CITY OF ALBUQUERQUE

December 2, 2016

Re: Storage Facility for Derron Havehor
809 Locust St., SE
30-Day Temporary Certificate of Occupancy- Transportation Development
Architect's Stamp dated 03-10-16 (K15D096)
Certification dated 11-30-16

5 HANDICAP PARKING SIGN Scale: 1" = 1'-0"

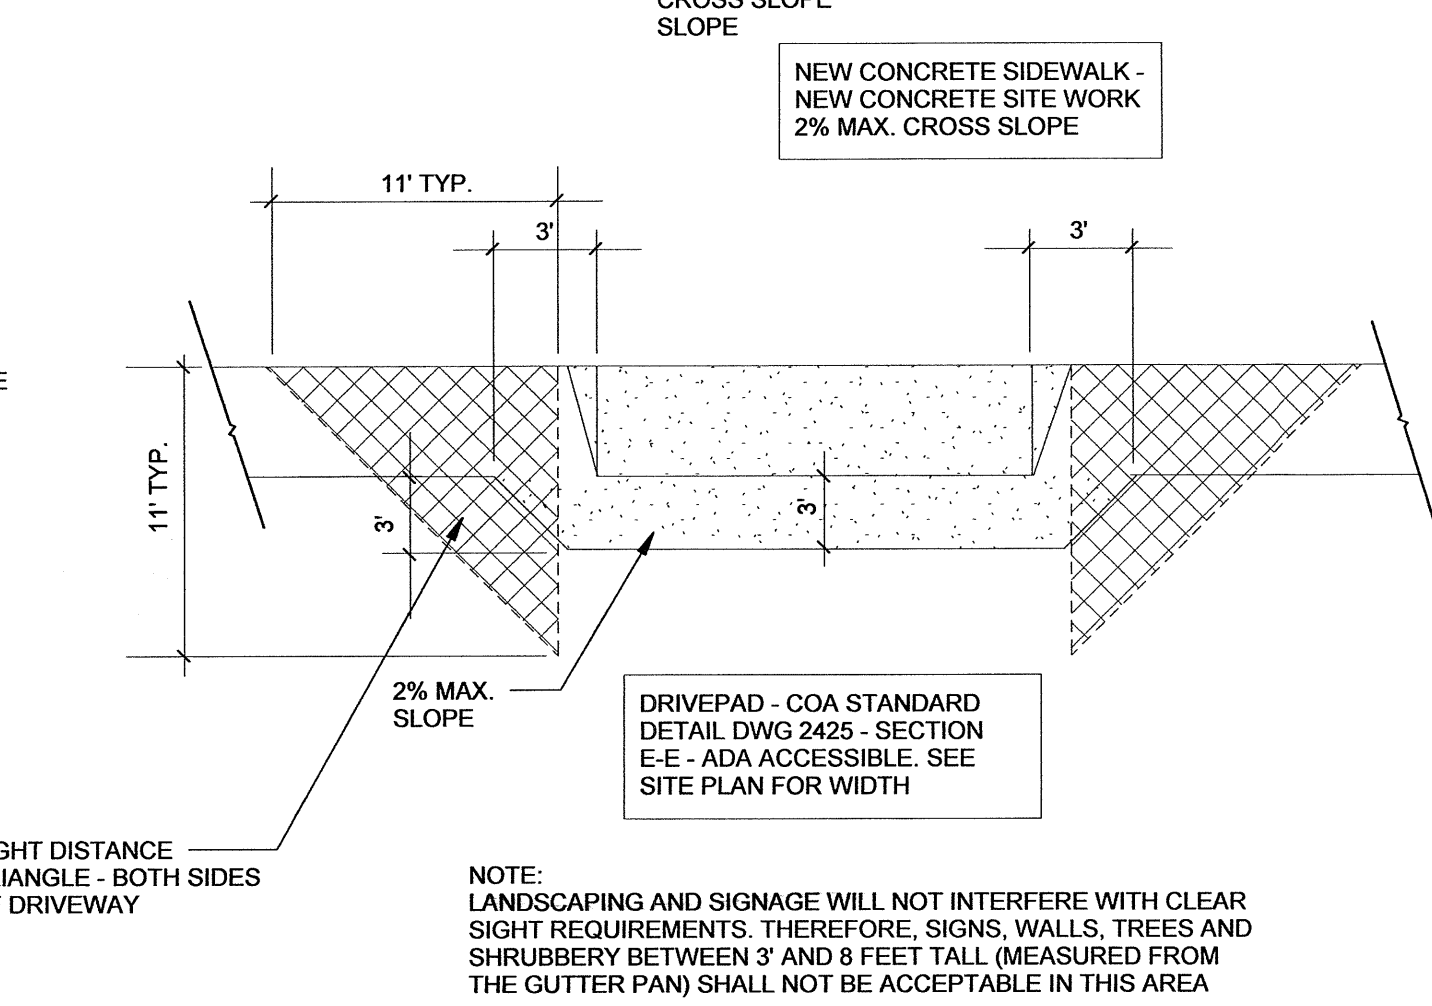
1. The bottom of the ADA sign must be a minimum of 60" above the ground or parking surface. (ANSI 502.7)
2. The ADA accessible parking sign must have the required language per (66-7-352.4C NMSA 1978) **"Violators Are Subject to a Fine and/or Towing."** Please call out detail and location of HC signs.
3. The ADA access aisles shall have the words **"NO PARKING"** in capital letters, each of which shall be at least one foot high and at least two inches wide, placed at the rear of the parking space so as to be close to where an adjacent vehicle's rear tire would be placed. (66-1-4.1.B NMSA 1978)
4. The ADA parking space has a clearly visible, blue, International Symbol of Accessibility painted on the pavement at rear of the space (66-1-4.1.E NMSA 1978) or MUTCD recommends a white symbol on a blue background.
